TECHNICAL NOTE

Project	Unit 1, Caxton Trading Estate, Hayes		
Document	Transport Addendum Note		
Reference No	25159/N01	Date	6th July 2026
Prepared By	Adam Humphries	Reviewed By	Kamran Haider

1. Pulsar has been commissioned by Zongwise Ltd to provide transport advice in relation to the proposed redevelopment of Unit 1, Caxton Trading Estate, Printing House Lane, Hayes, UB3 1BE. The London Borough of Hillingdon (LBH) act as the local planning authority and local highway authority.
2. A planning application (Ref: 50369/APP/2026/127) was submitted to LBH in January 2026 for the following:

1 Proposed Ground Floor Plan
Scale: 1:150

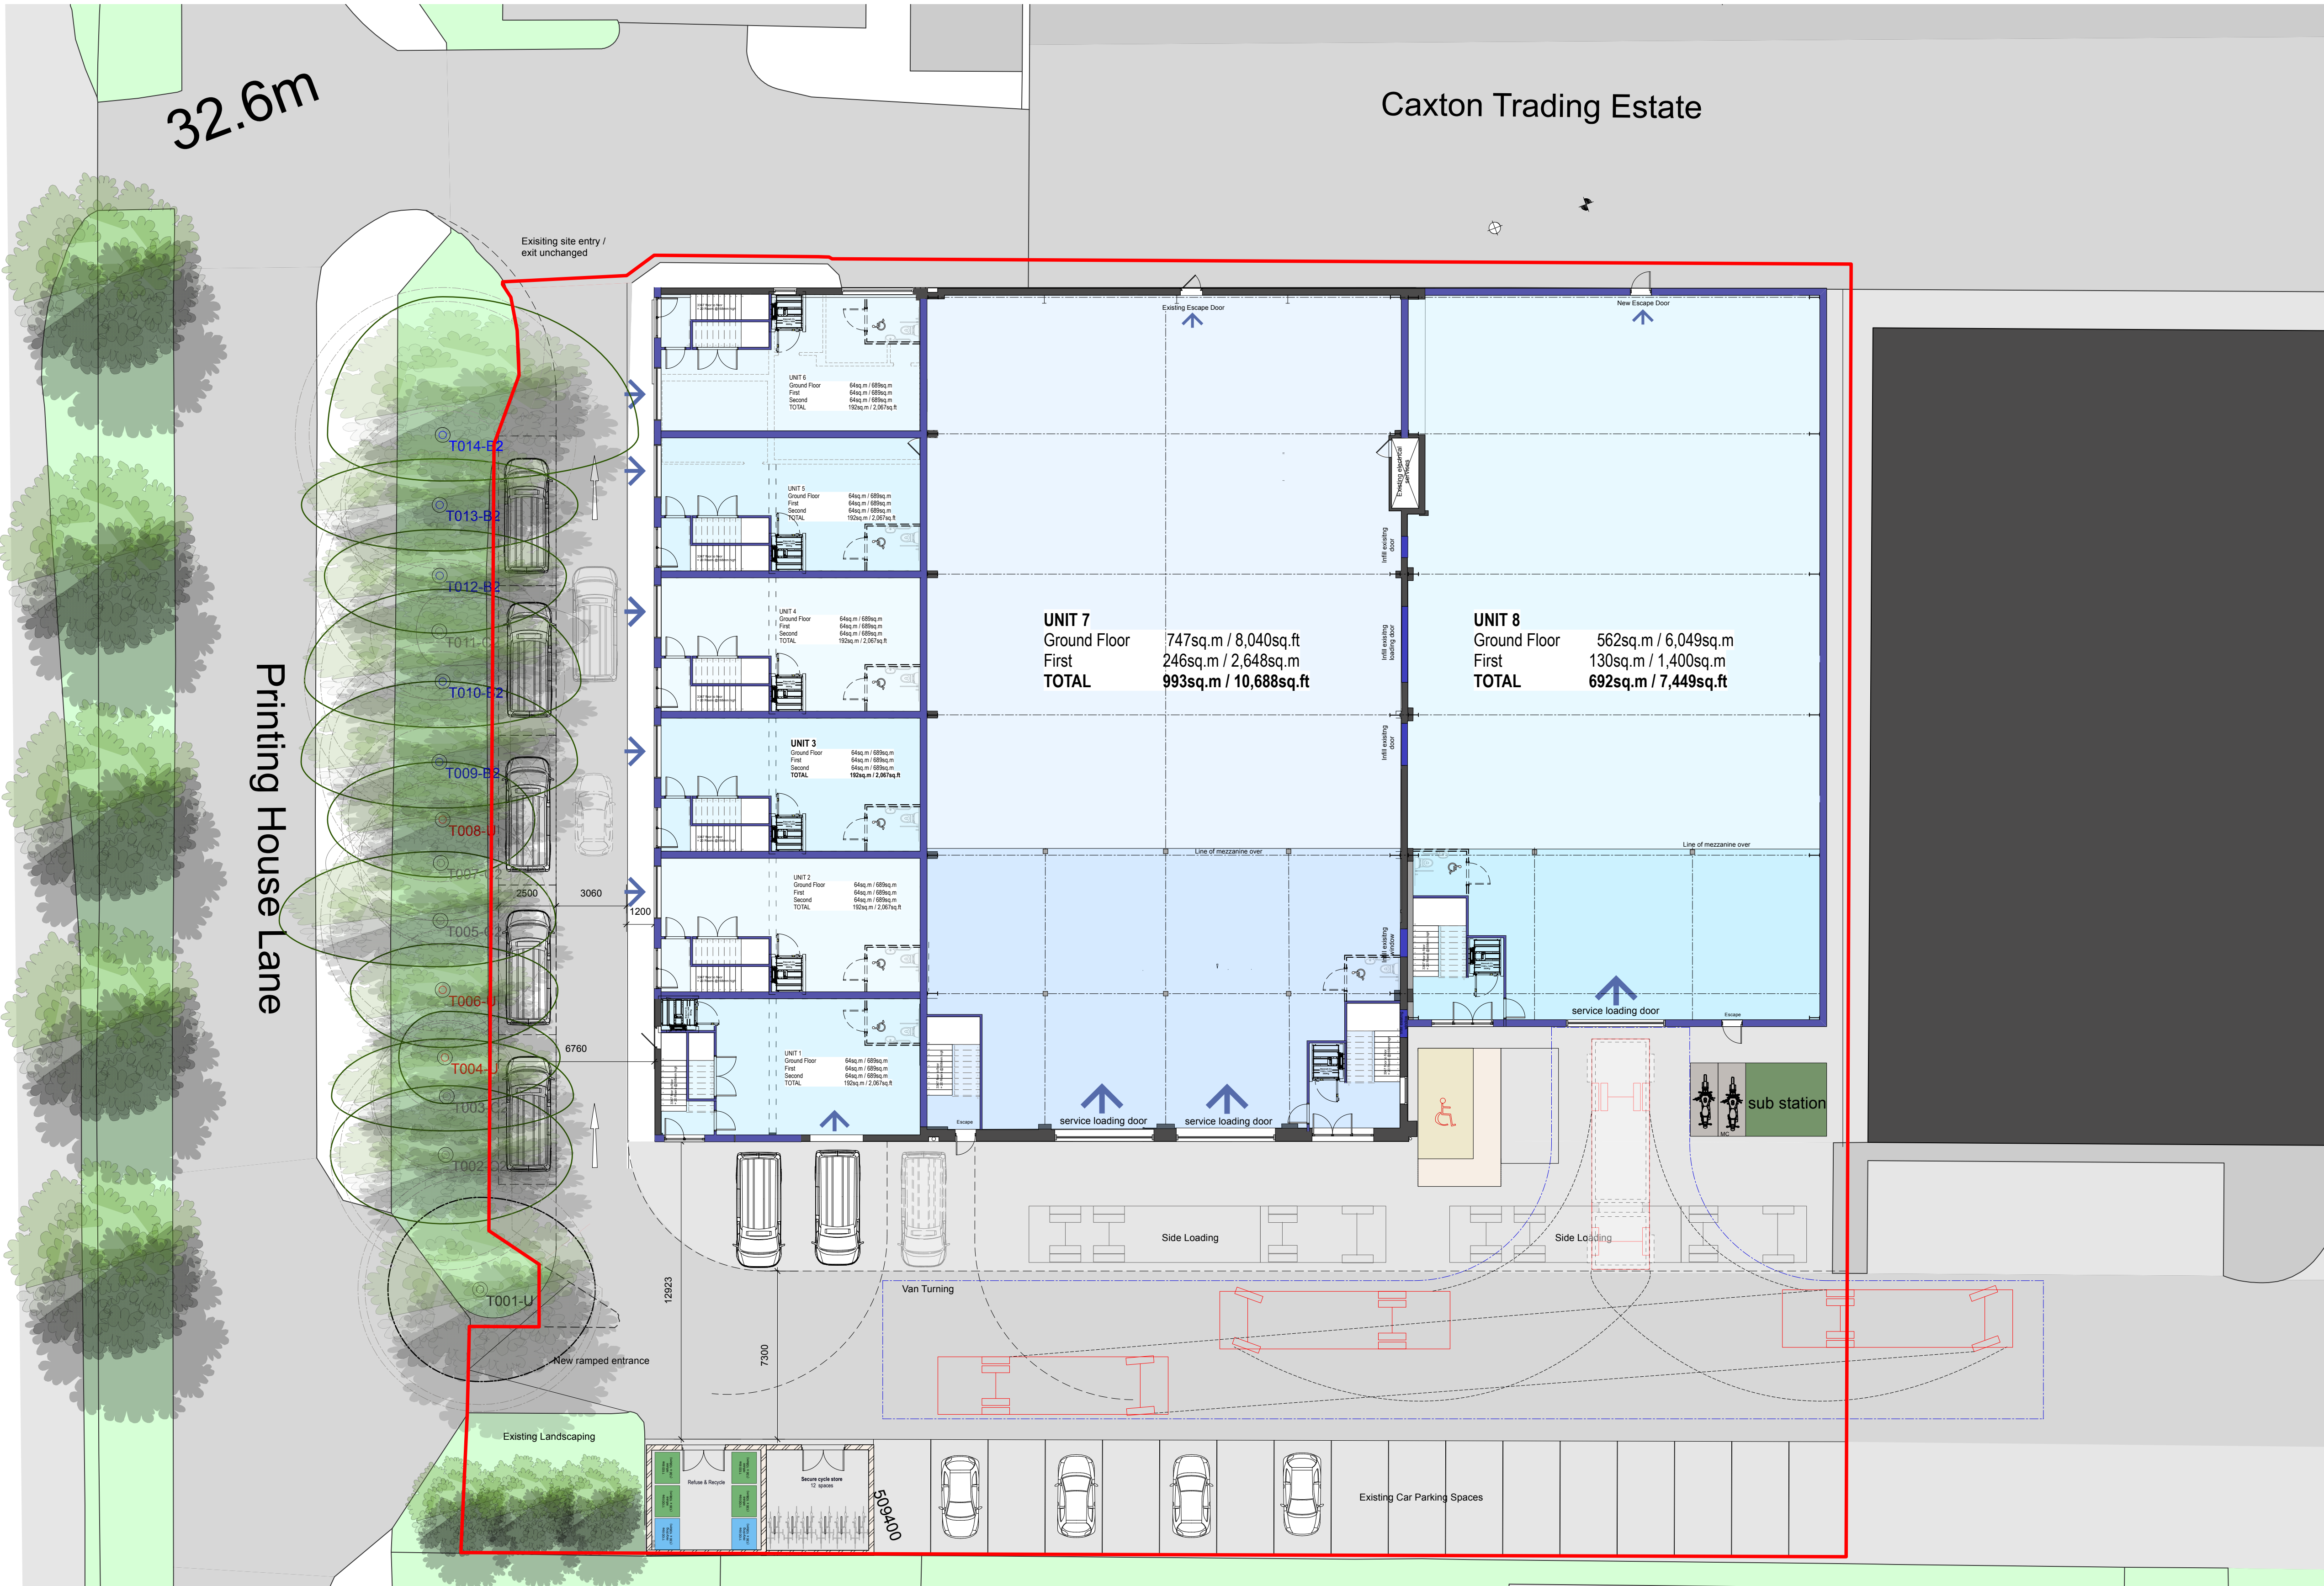
The submitted tracking shows that the vehicle paths required for turning extend beyond the applicant's red line boundary, entering adjacent third party land. This is not permissible unless legal rights of access are demonstrated. Third party landowners may restrict access, alter their layout, or secure their boundary with

fencing at any time. Without clear evidence of an existing enforceable right to use this land for vehicular manoeuvring, the proposed turning arrangement for rigid vehicles cannot be accepted.

Furthermore, the layout drawings annotate the presence of articulated vehicles described as “side loading”, which confirms that articulated HGVs will visit the site. However, no swept path drawings have been provided showing how articulated vehicles would enter, manoeuvre within, or exit the site in forward gear, as required under Manual for Streets principles and Highway Authority standards.

In the absence of acceptable, in-boundary swept path assessments for both rigid and articulated vehicles, the turning and servicing arrangements are not demonstrated to be safe or operationally workable and therefore cannot be supported.

5. Some minor updates to the ground floor and servicing layout of the proposed scheme have been included, as shown in the latest Architect’s Layout in **Appendix A**. Updates include the removal of four car parking spaces in the southwest corner of the site, to allow space for a rigid lorry to reverse into the proposed loading bay.
6. Further to this, **Appendix B** includes updated swept path analysis to show that a rigid lorry using the loading bay is able to turn around within the curtilage of the site and within the red line boundary.
7. The revised layout demonstrates that all servicing manoeuvres can now be undertaken entirely within the application site, removing the previous reliance on adjoining land and ensuring that vehicles can enter and exit the site safely and in a forward gear.

19. An updated site layout has been provided, alongside a swept path analysis drawing, which shows that rigid lorries are able to safely reverse into the proposed loading area, without needing to leave the curtilage of the site or red line boundary.
